TOWN AND COUNTRY PLANNING ACT**HIGHWAY REPORT ON PROPOSALS FOR DEVELOPMENT**

DISTRICT:	Bassetlaw	Date received	24/08/2022
OFFICER:	John McKeown		
PROPOSAL:	Demolition of Existing House and Outbuildings and Construction of Replacement House and Garage	D.C. No.	B/22/01109/FUL
LOCATION:	High Ridge Top Street Askham Newark Nottinghamshire NG22 0RP		
APPLICANT:	Mr Jonathan Allbones

site plan as proposed. ( roof plan )

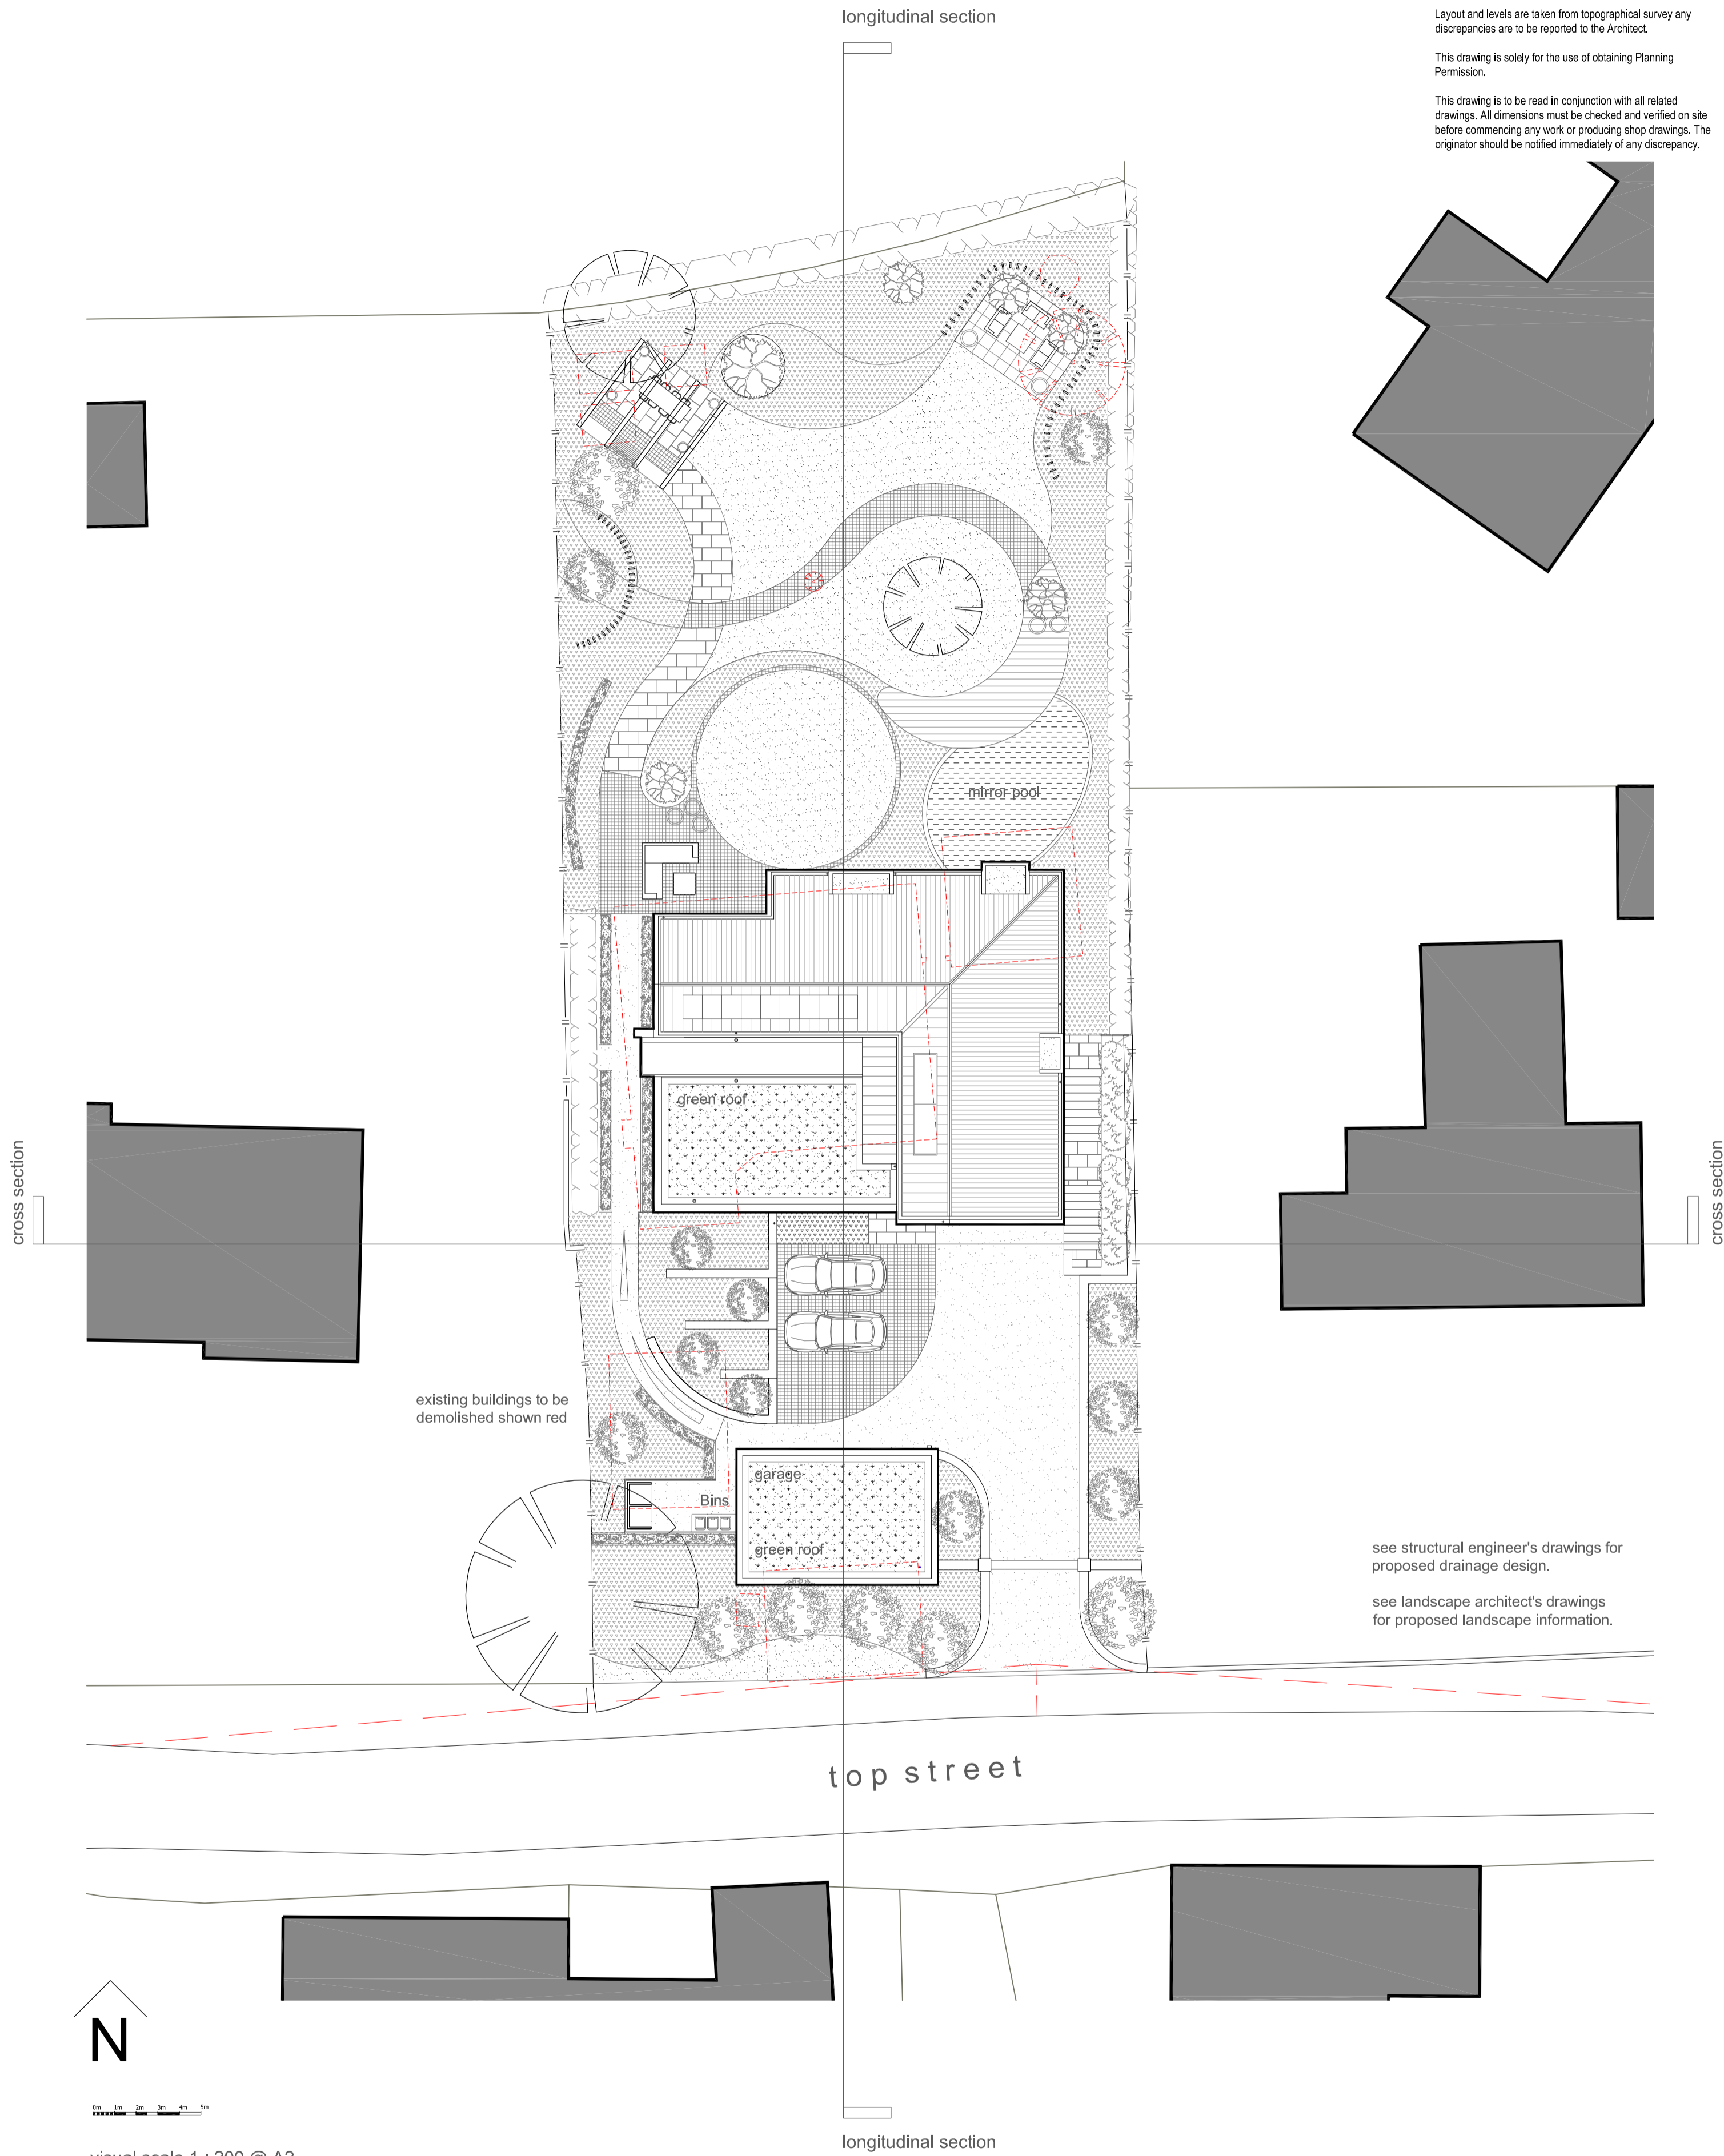
The application is for a replacement dwelling that retains access in its current position. There are therefore no objections on highway grounds subject to conditions to ensure that the amendments to the site layout are suitably carried out.

- Prior to the dwelling being occupied the existing Top Street frontage hedge shall be removed. The centre line of any new or relocated Top Street frontage hedge shall be positioned no less than 1.0m to the rear of the Top Street site boundary and shall be retained in that position for as long as the hedge remains in existence.

- The dwelling shall not be occupied until such time as the driveway has been provided in a bound material (not loose gravel) for a minimum distance of 6.0m into the site from the site boundary and which shall be drained to prevent the unregulated discharge of surface water onto Top Street.
